WILKINS ENGINEERING, P.C.

November 21, 2023

SUBJECT: Masonry Basement Wall Construction
145 Alice Holleman Lane
Fuquay Varina, North Carolina
Permit #SFD2303-0023

FIRST FLOOR STR. PLAN

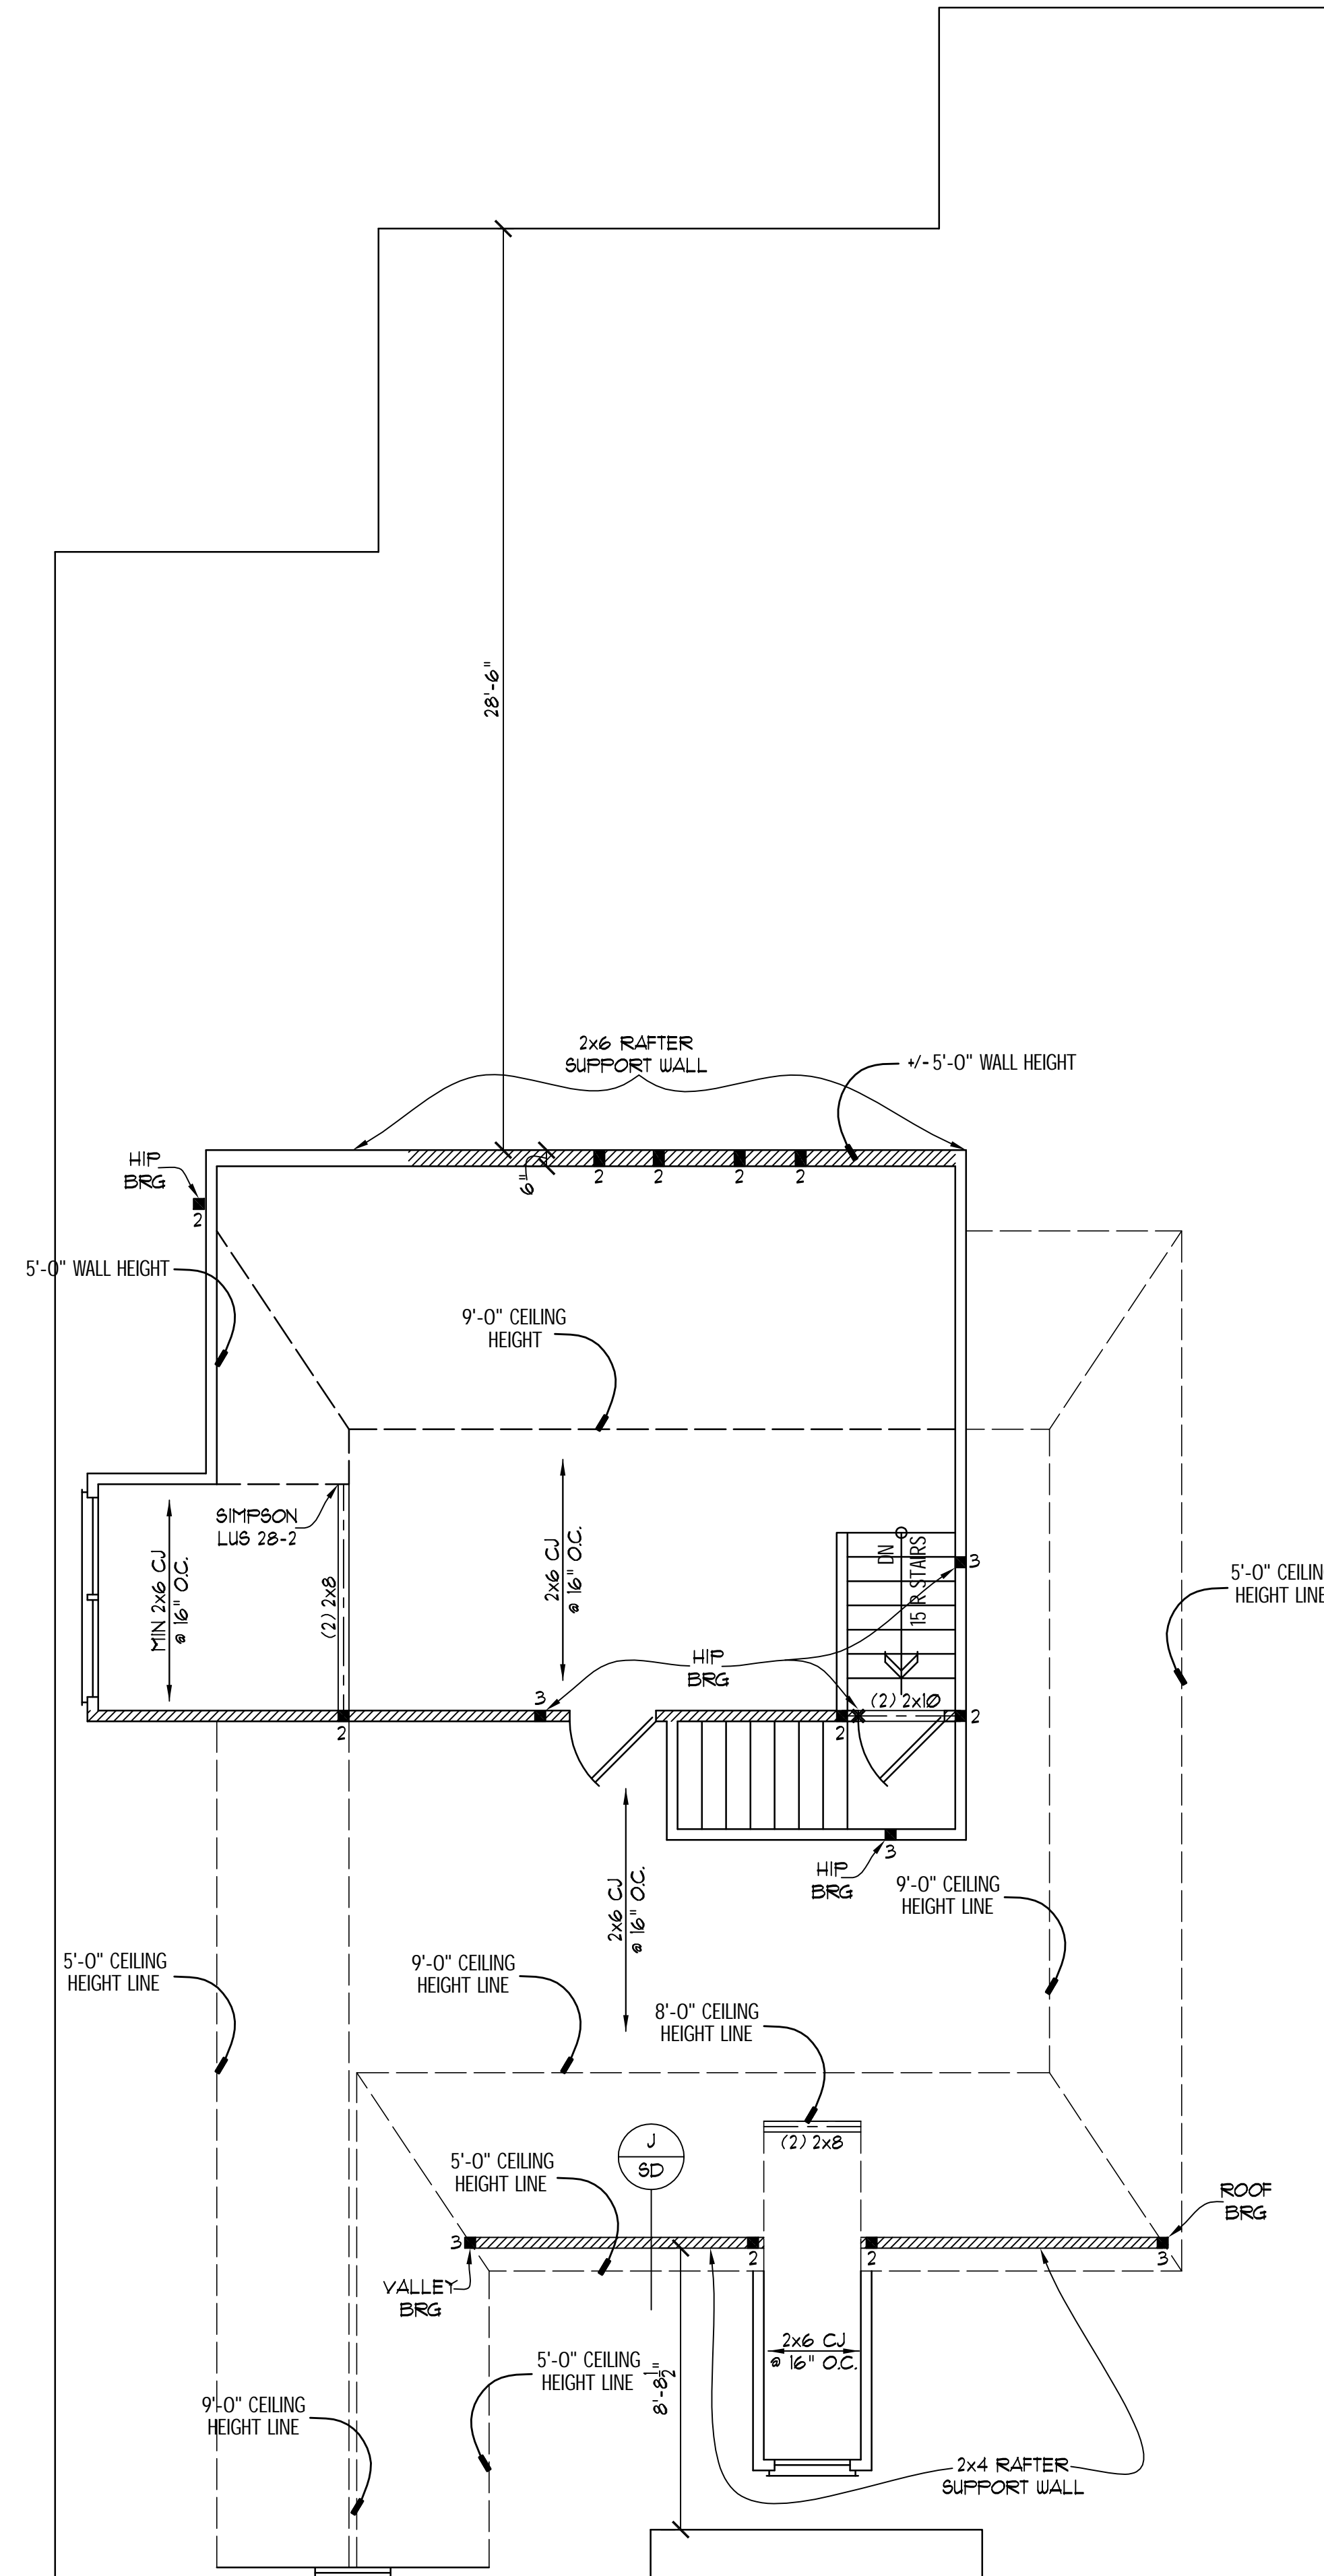
The header installed over the rear door to the screened porch is supported by three jack studs under each end of the header. The header is a multiple ply LVL member which supports the reaction end of the steel beam in the ceiling, and numerous king studs are installed on either side of the jack studs. I find this installation to be structurally adequate to support the reaction load from the steel beam and no modification or addition is required. First level ceiling joists have been notched and are framed into the steel beam. The original framing detail provided by the designer showed the steel beam packed out with 2"x 10" members. However, the method used is a more efficient way of supporting these ceiling joists.

ROOF FRAMING PLAN

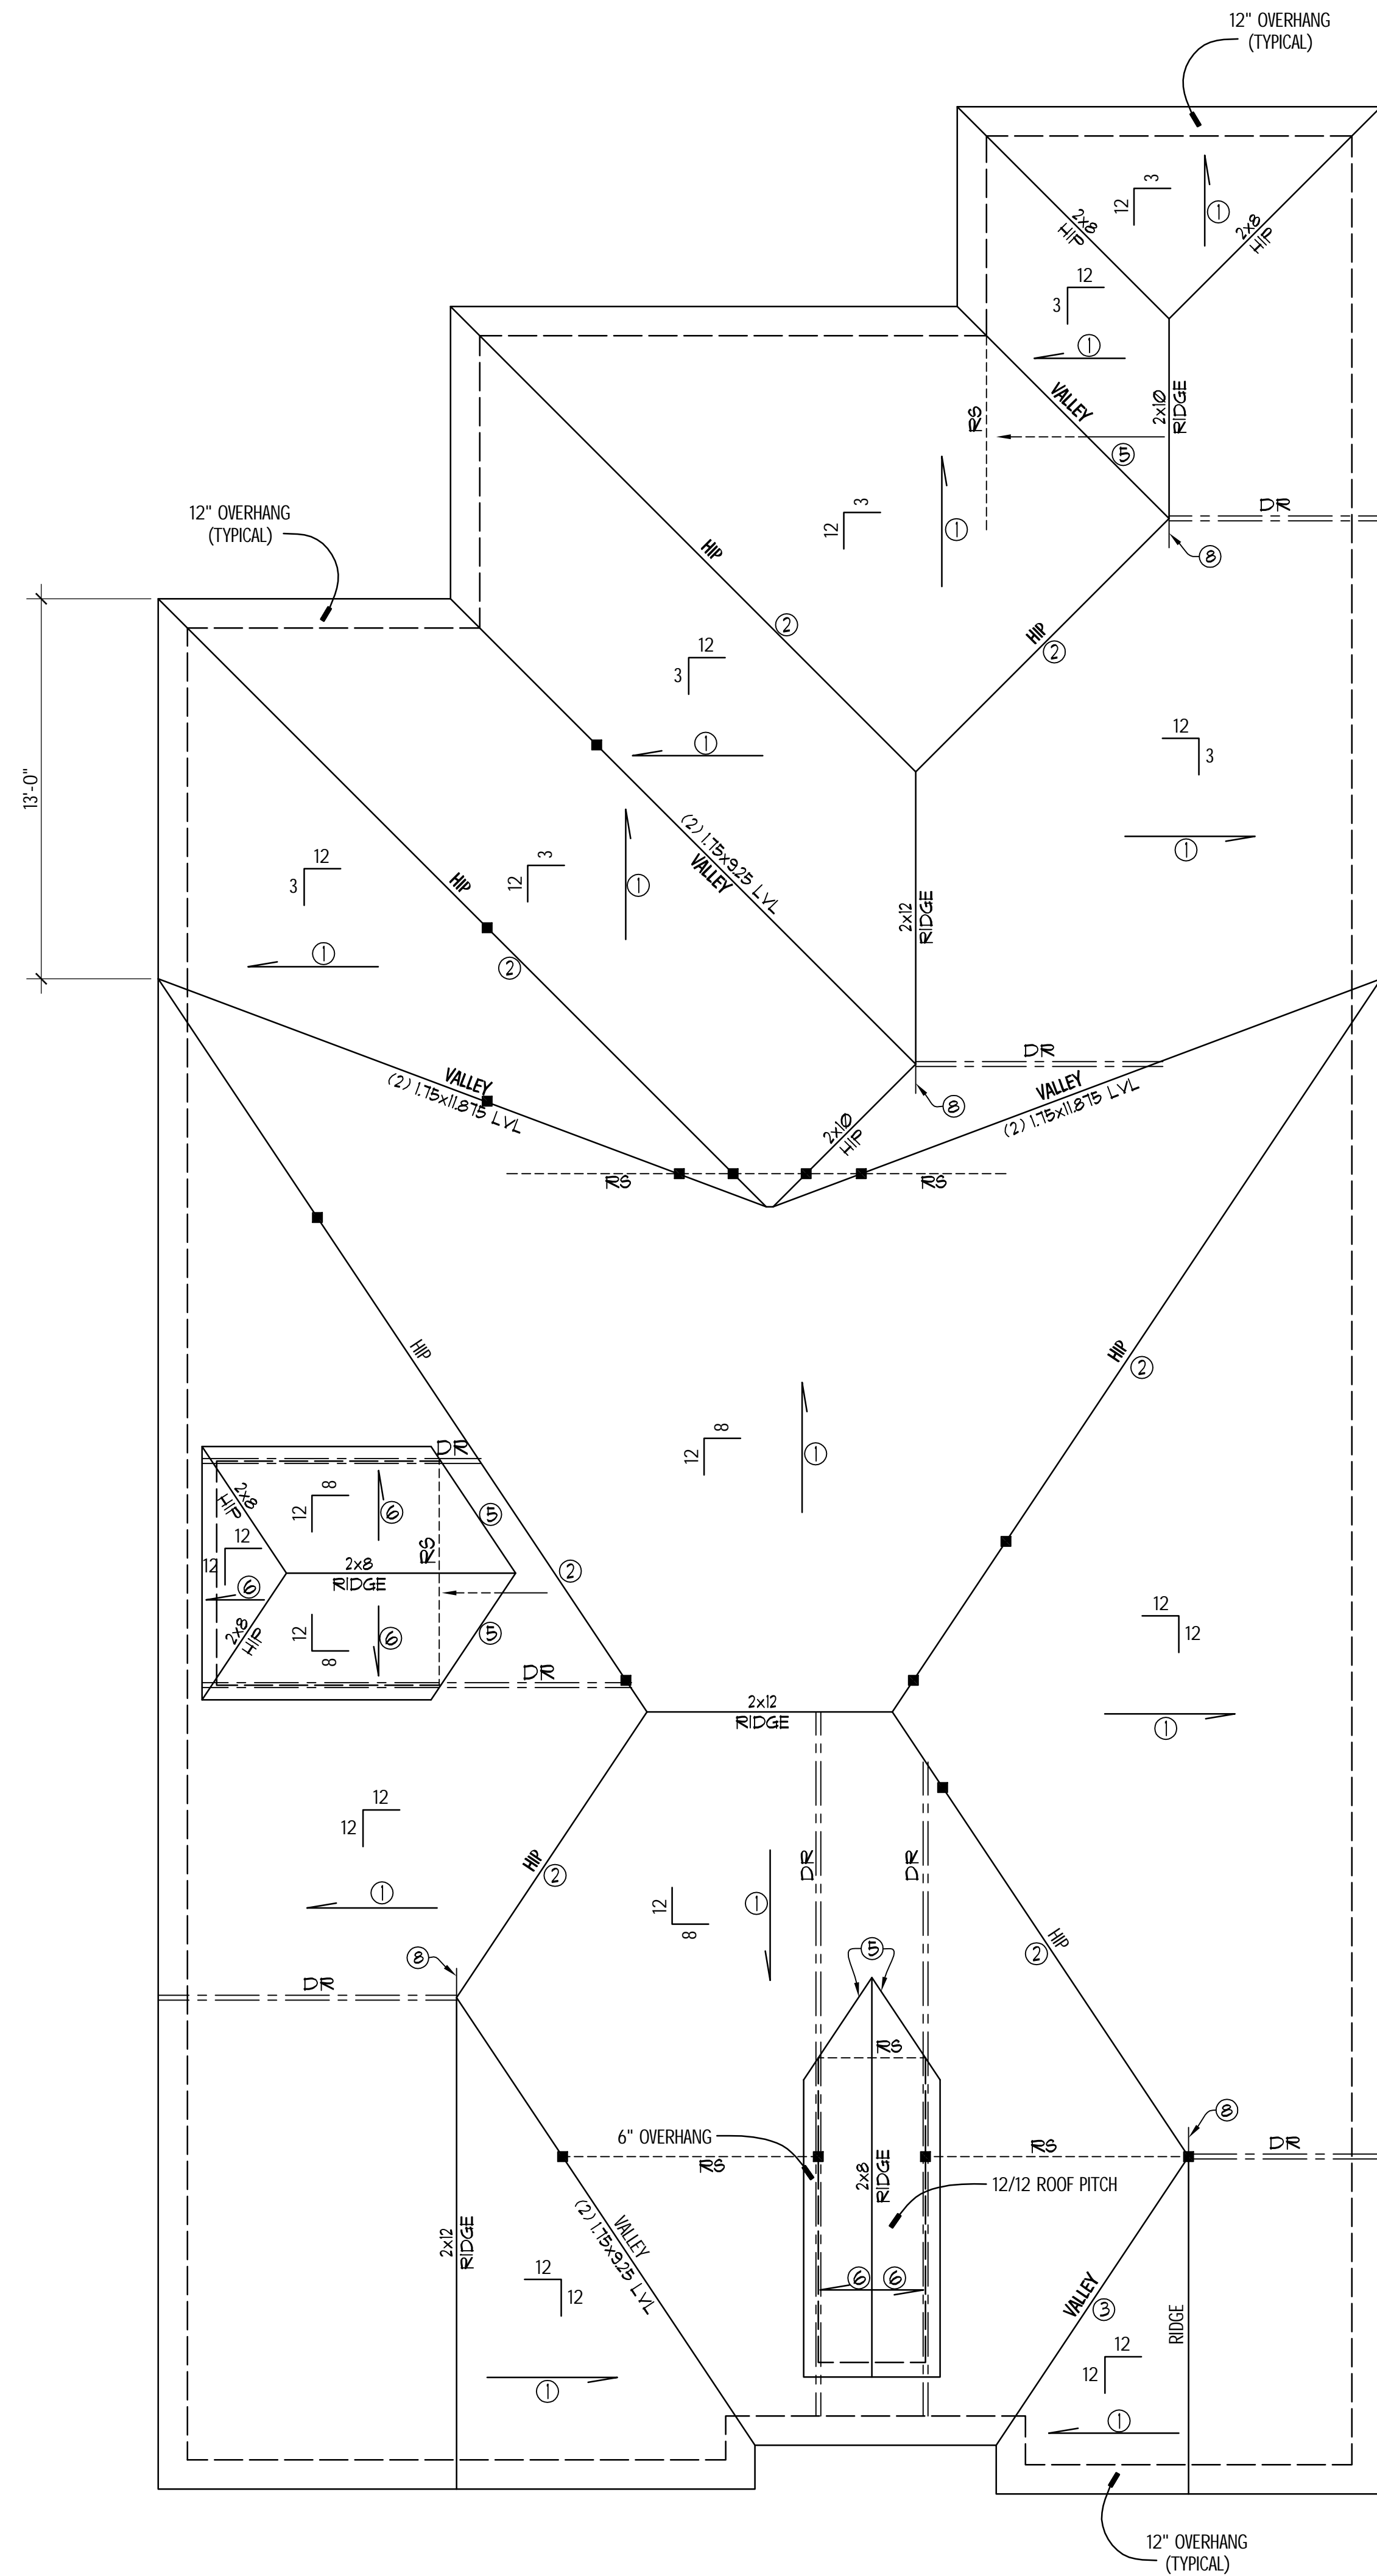
The last item to be covered is the location of the stiff knee support of the hip rafters on the second level of the structure. The support is located over a center load bearing wall

and my inspection revealed that the hip rafter is properly supported. No additional support or framing is required.
